**KIRKLEES METROPOLITAN COUNCIL
INVESTMENT & REGENERATION SERVICE**

DELEGATED DECISION TO DETERMINE PLANNING APPLICATIONS

Reference No: 2018/62/92073/E

Site Address: Staincliffe Hall, Staincliffe Hall Road, Staincliffe,
Batley, WF17 7QU

DETACHED GARAGE

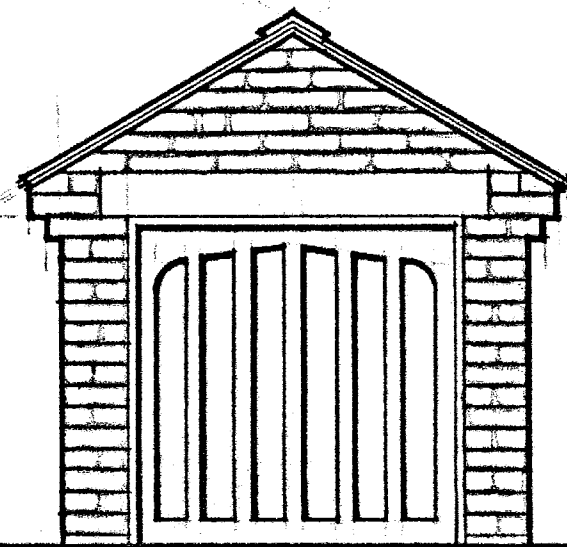
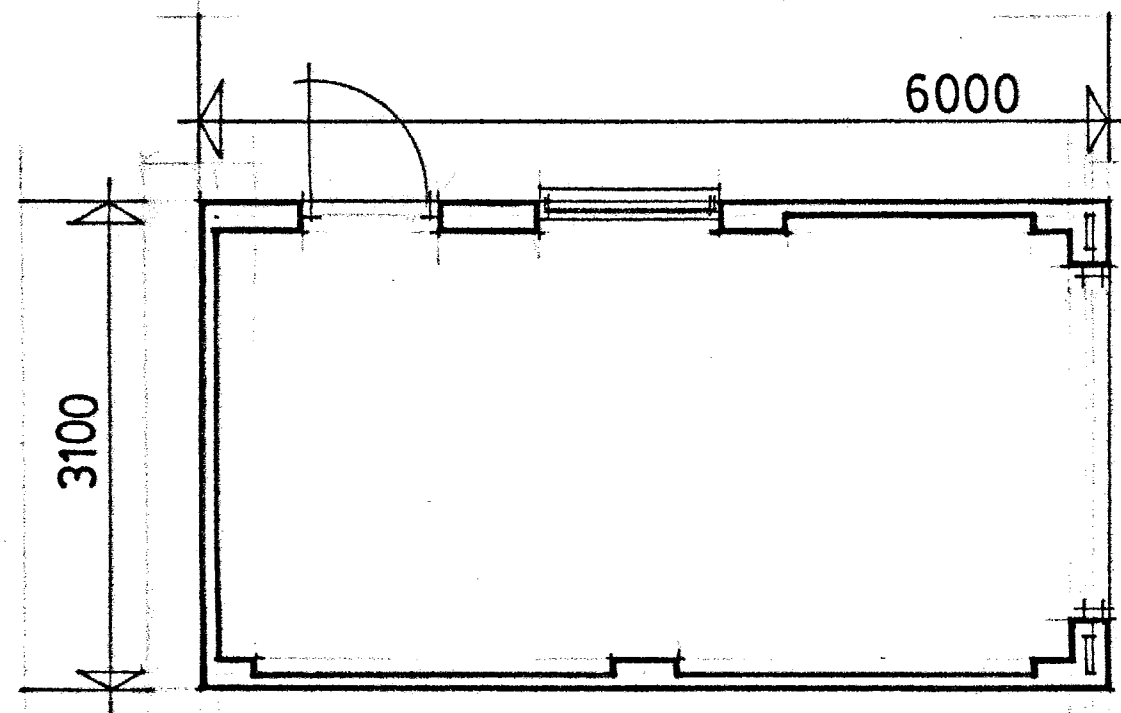
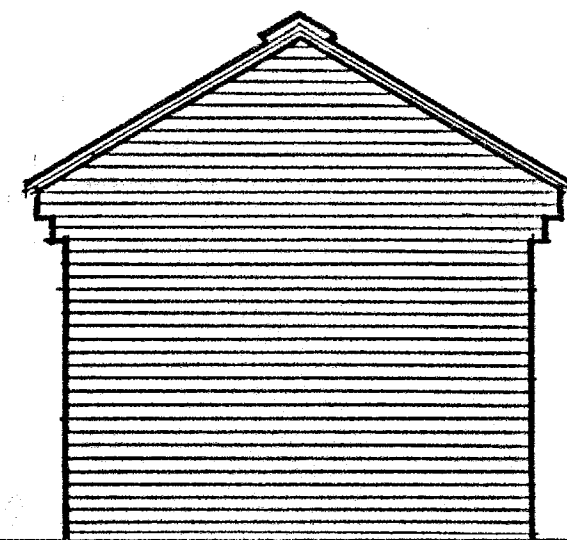
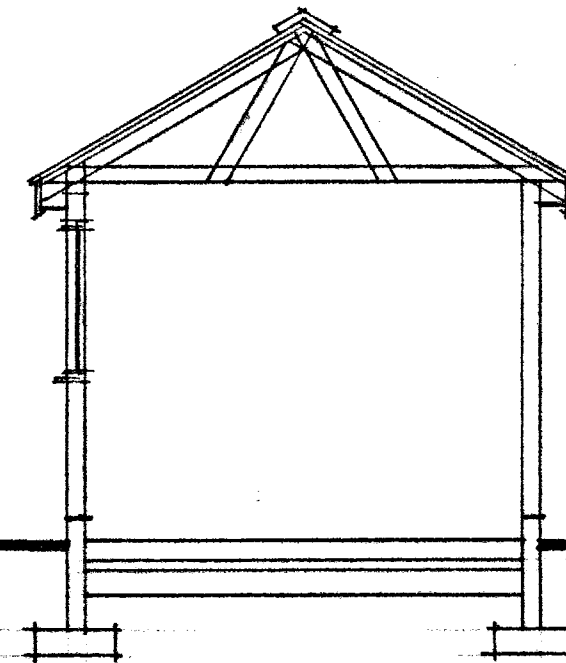
The Council's Conservation and Design team leader was consulted and considered the impact upon the setting of the listed building to be satisfactory, however they had concerns about the impact upon visual amenity generally. They suggested that it should look more like a coach house, with centrally placed porch / lobby and bays to either side with windows, not French doors.

These alterations are reflected in amended plans received on 21st August 2018, and are considered to be acceptable.

BLOCK PLAN
SCALE 1:200

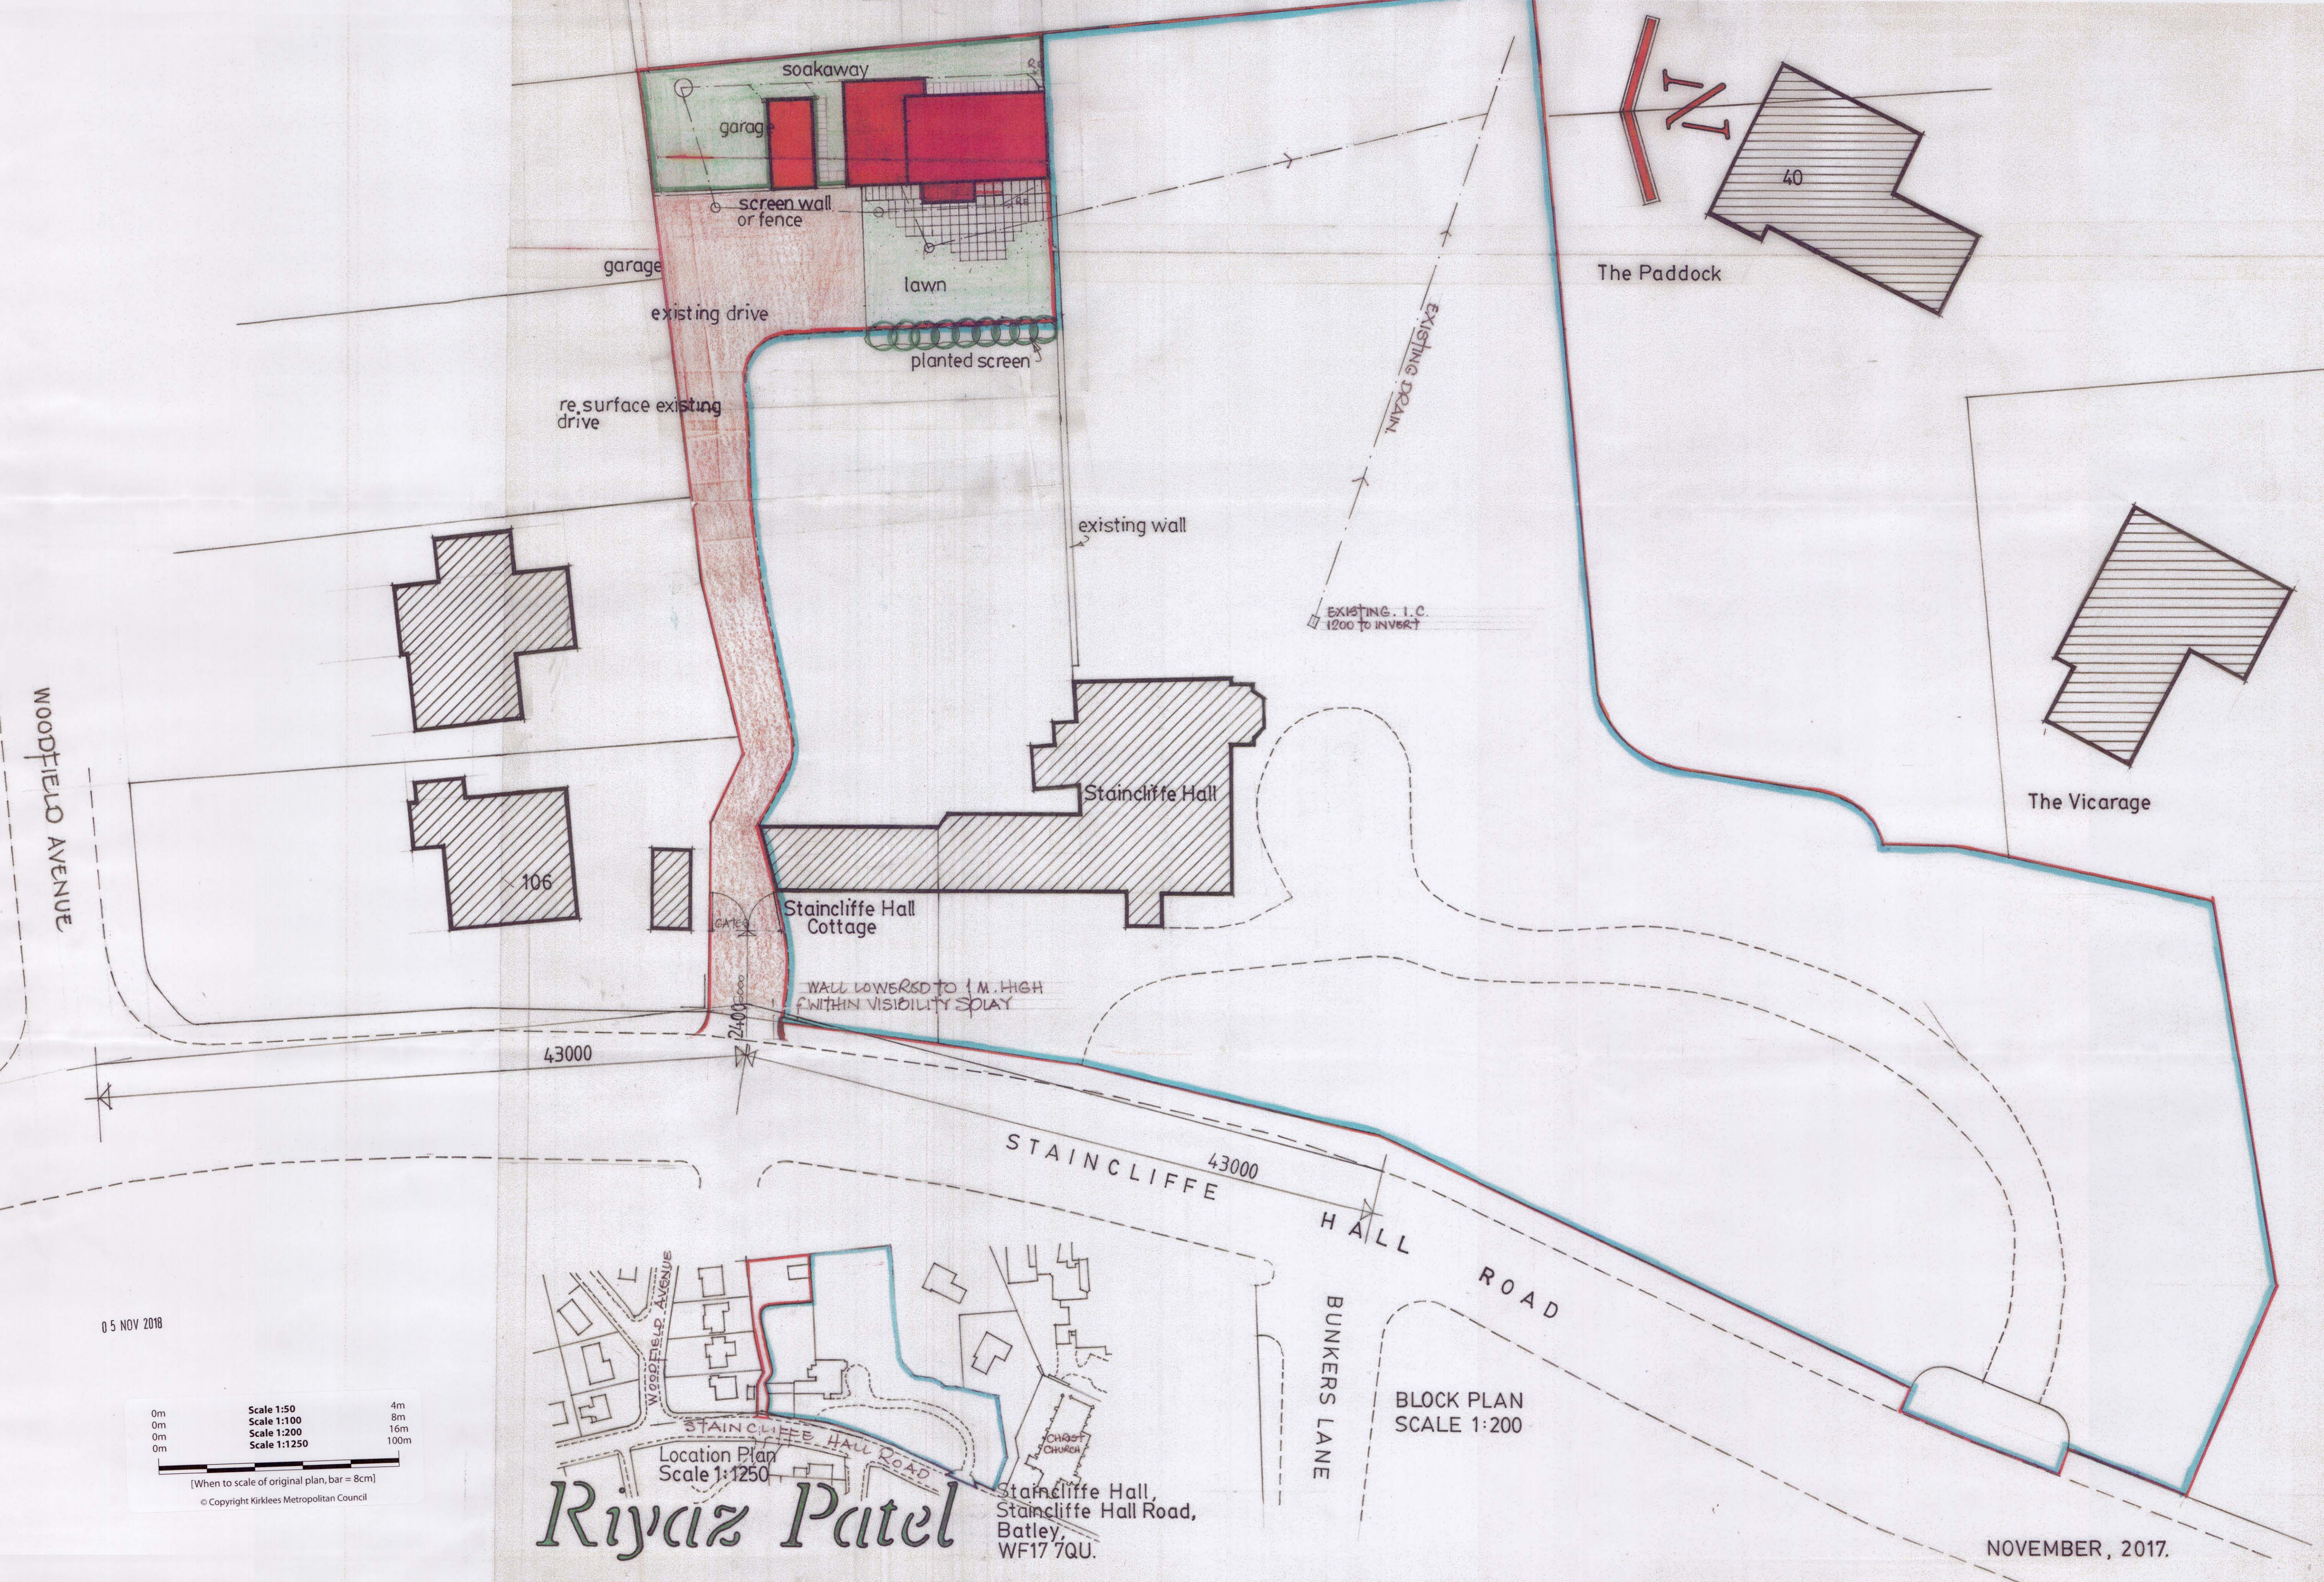
The Council's Highways officers have been consulted and initially were concerned about sight lines. These are now shown on the block plan and the whole scheme is considered acceptable from a highway safety point of view.

- The existing drain shown on the block plan is incorrect

Response: If it can't be proven that they can effectively connect to this system then a drainage survey may need to be undertaken or an alternative solution may need to be submitted. At the present moment it is still recommended to connect to a mains sewer.

5. The visibility splays, as shown on the submitted Block Plan received 5 November 2018, shall be completed before the development hereby approved is first brought into use. Thereafter, the visibility splays shall be retained.
